**CITY OF ALBUQUERQUE  
PLANNING DEPARTMENT**

**June 4, 2014  
DRB Comments**

**PROJECT # 1009785**

**RE: Lots 5 - 12, Block 33, Raynolds Addition**

**PLAT OF
LOTS 10-A, 11-A AND 12-A, BLOCK 33
RAYNOLDS ADDITION**

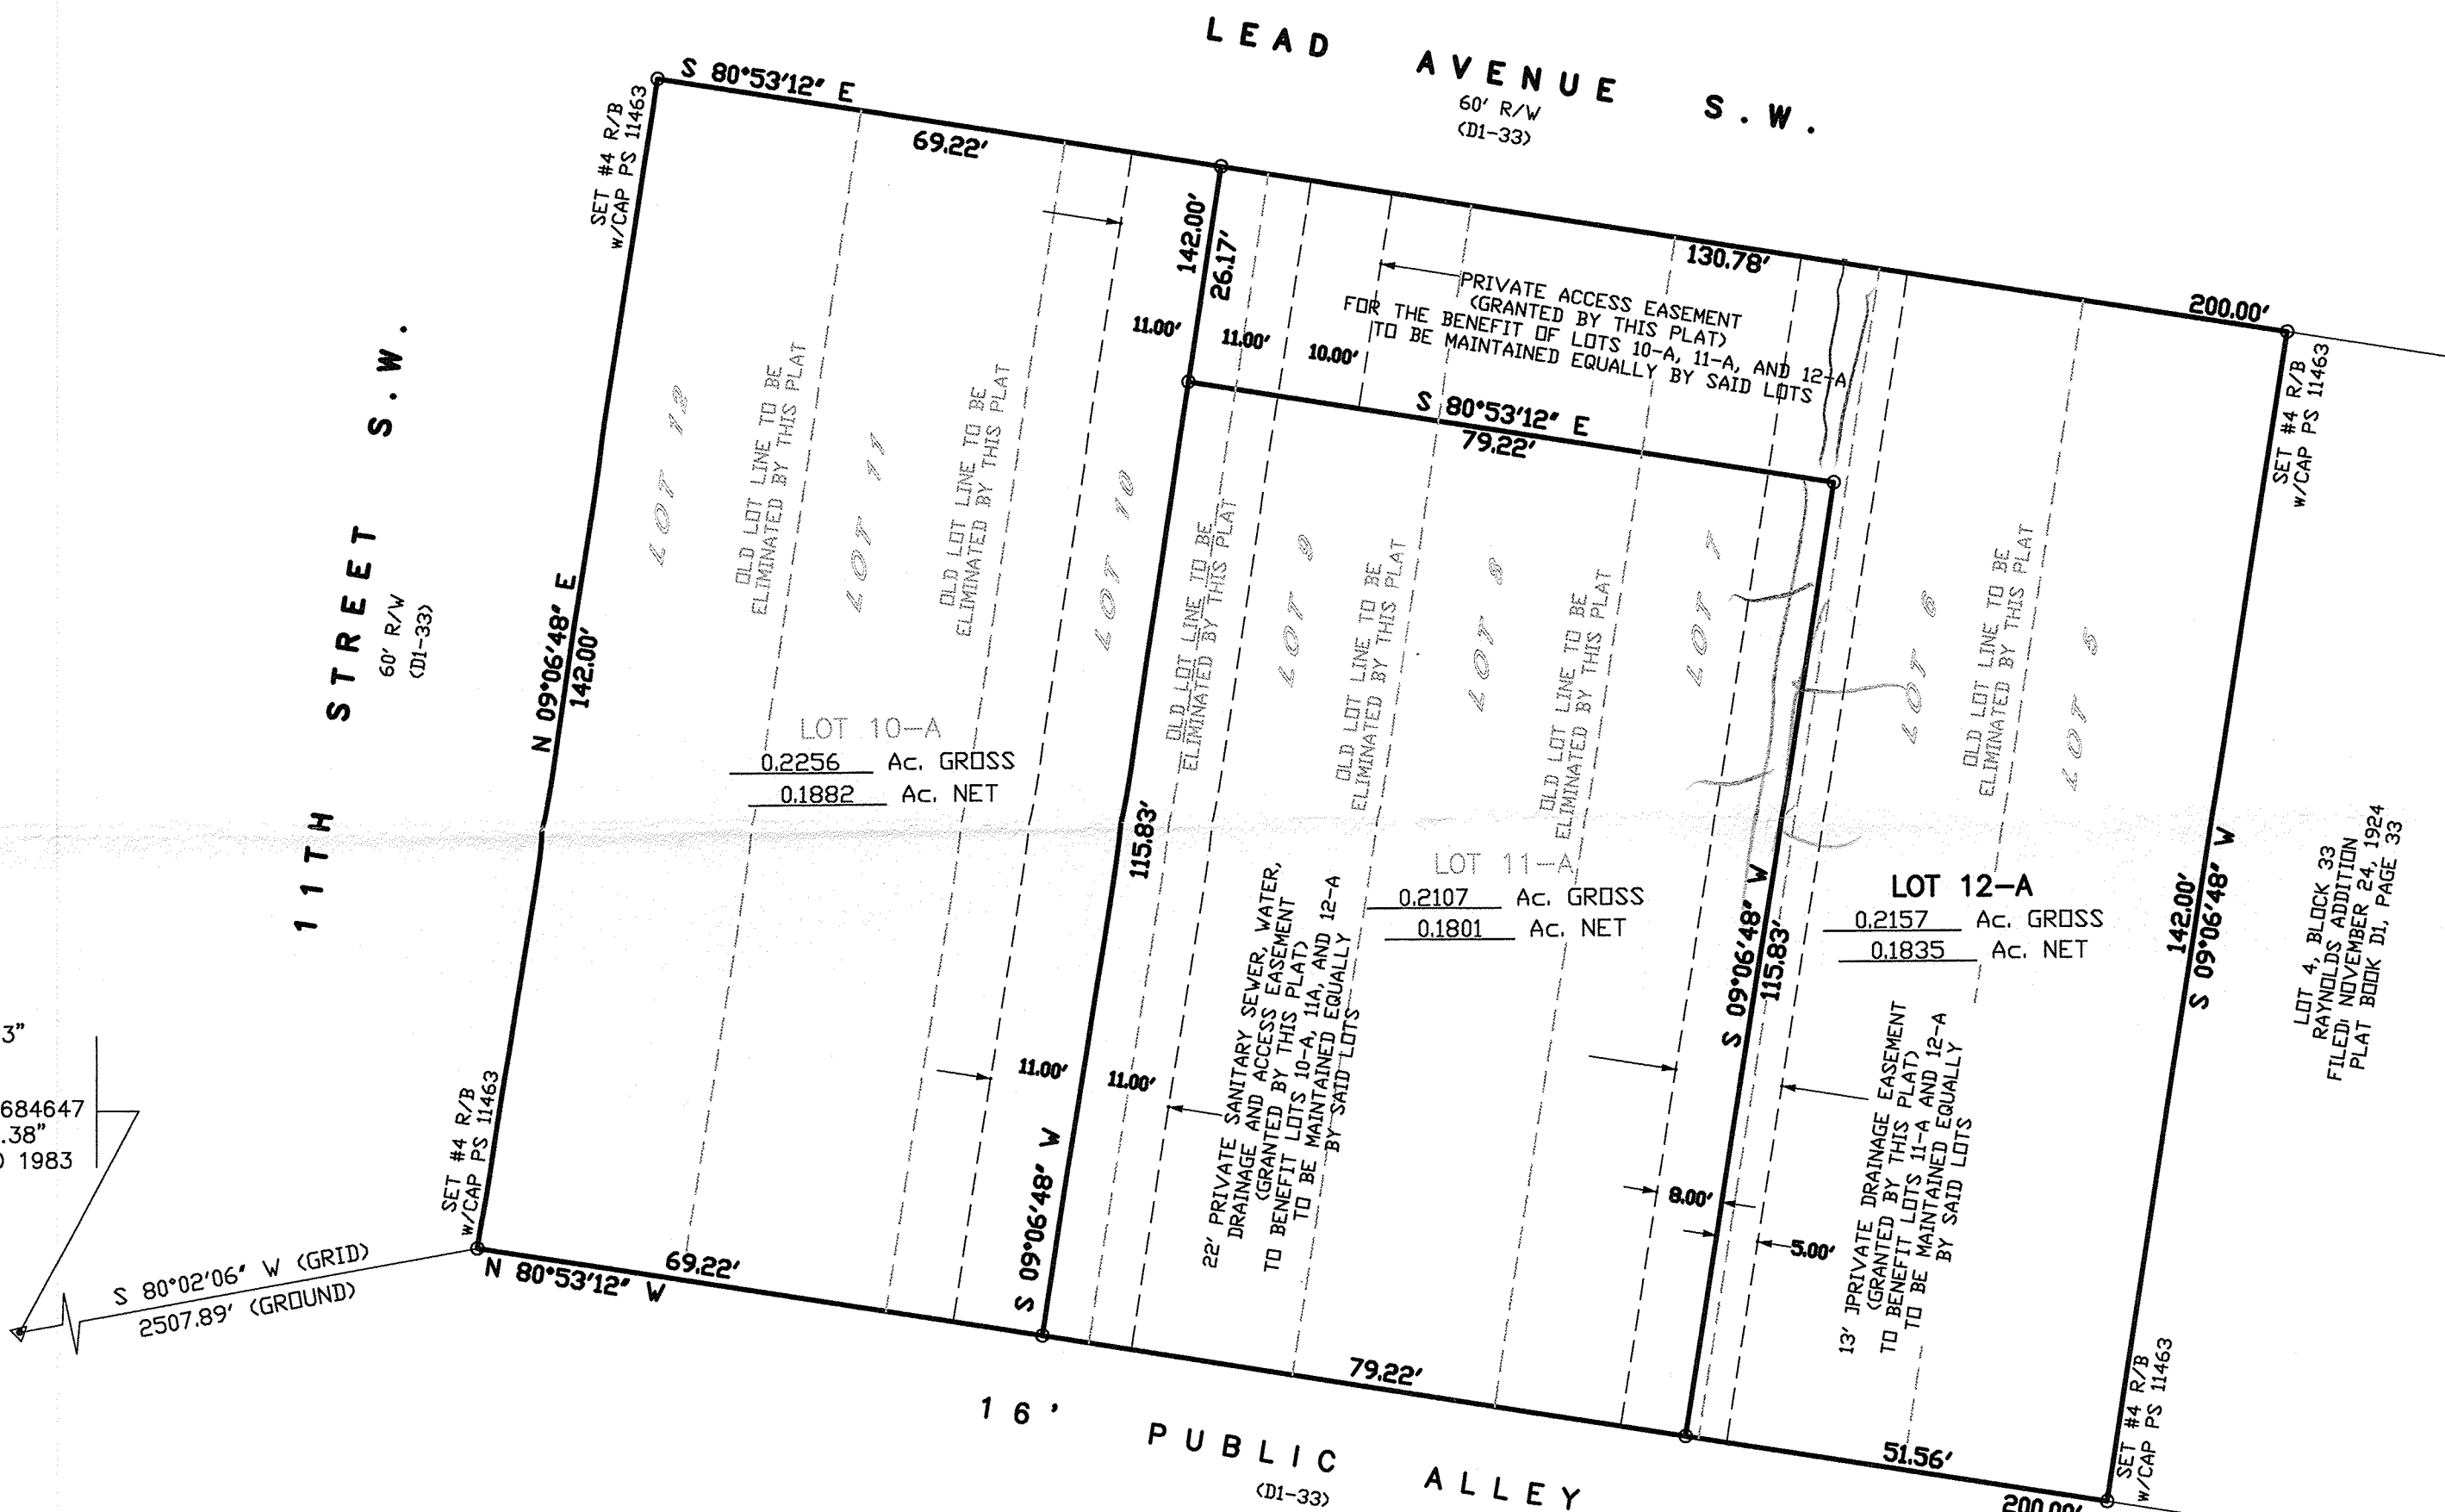
It is not clear from proposed site plan why the Private Access Easement is wider at Lead Ave than it is between proposed Lots 10-A and 11-A. A Reciprocal Pedestrian Access Easement is needed between proposed Lots 12-A and 11-A for the proposed sidewalk connection to Lead Ave.

LANDSCAPE PLAN - 1ST FLOOR SCALE: 1/8" = 1'-0"

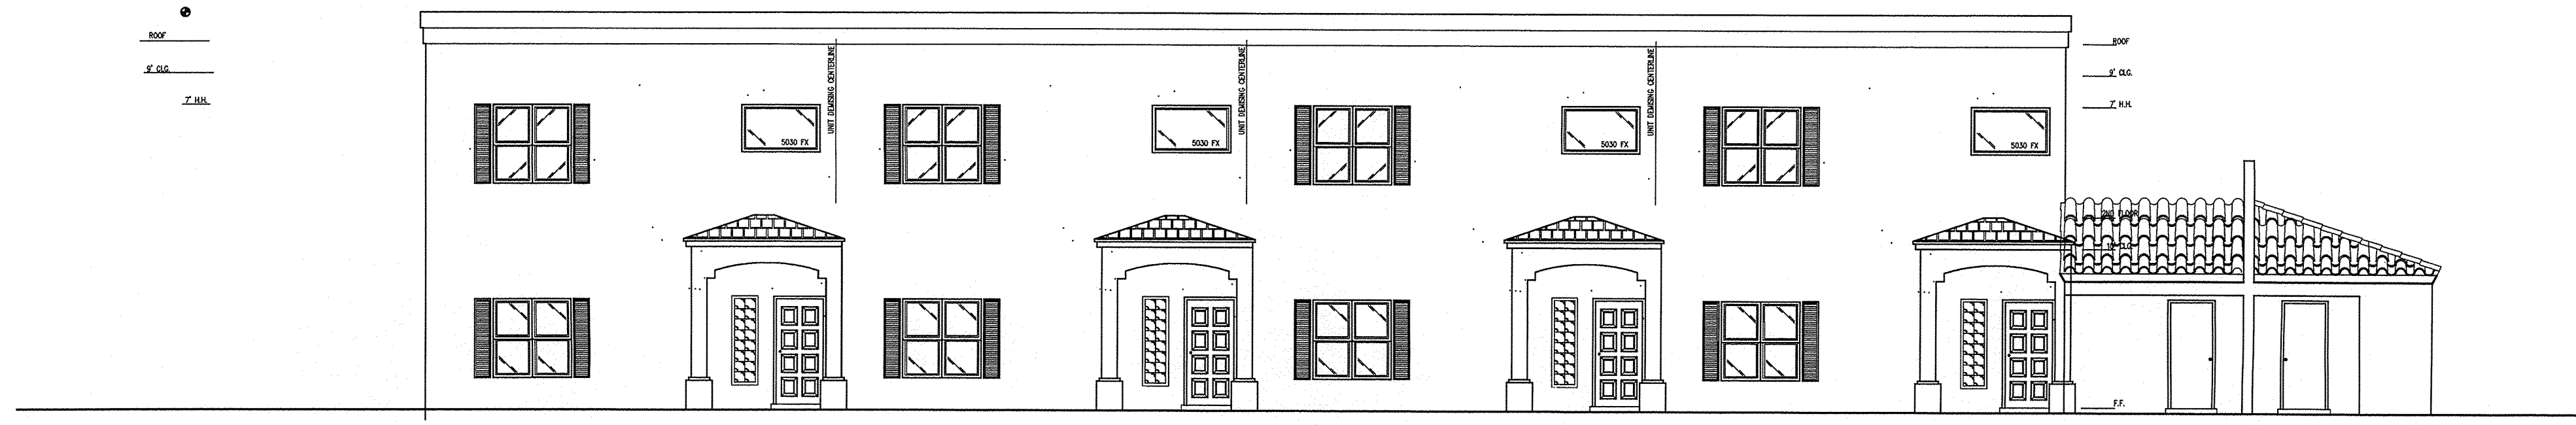
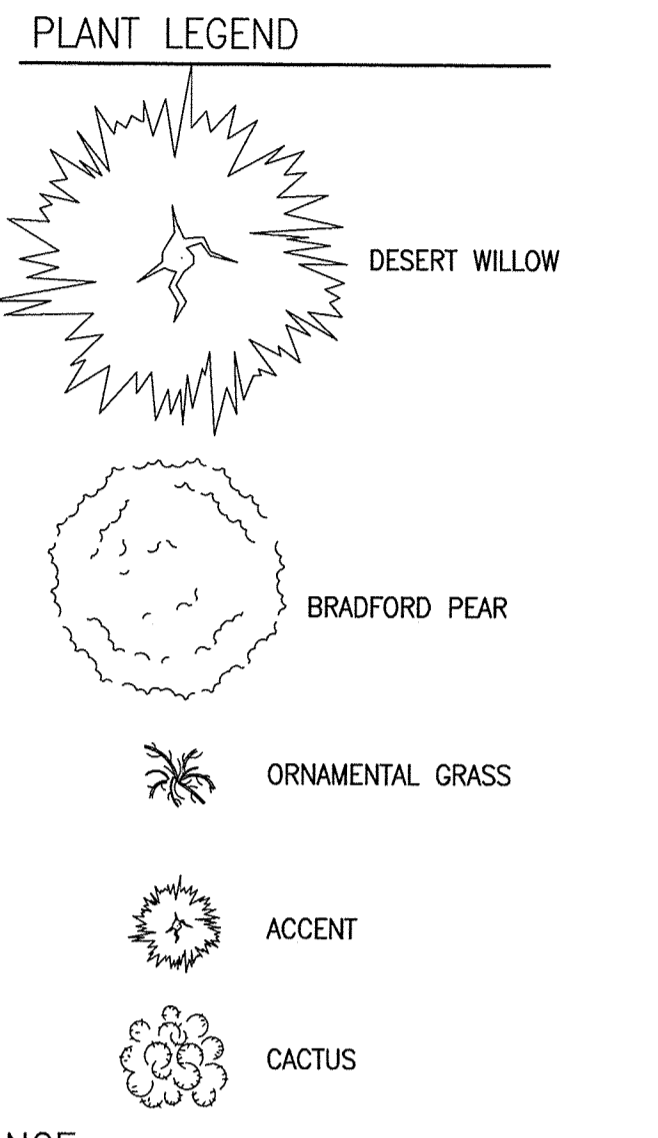
No objection to plat based on existing development. Site Development Plan approval by DRB is not required, however a site plan should be reviewed and verified by Zoning Enforcement prior to proceeding with plat, e.g. Huning Castle and Raynolds Addition Sector Plan calls for 400-600 sq ft of usable open space per unit depending on number of bedrooms (min 5,600 – 8,400 sq ft) but Landscape Plan only shows 4,796 sq ft; F.A.R. and parking requirement also apply.
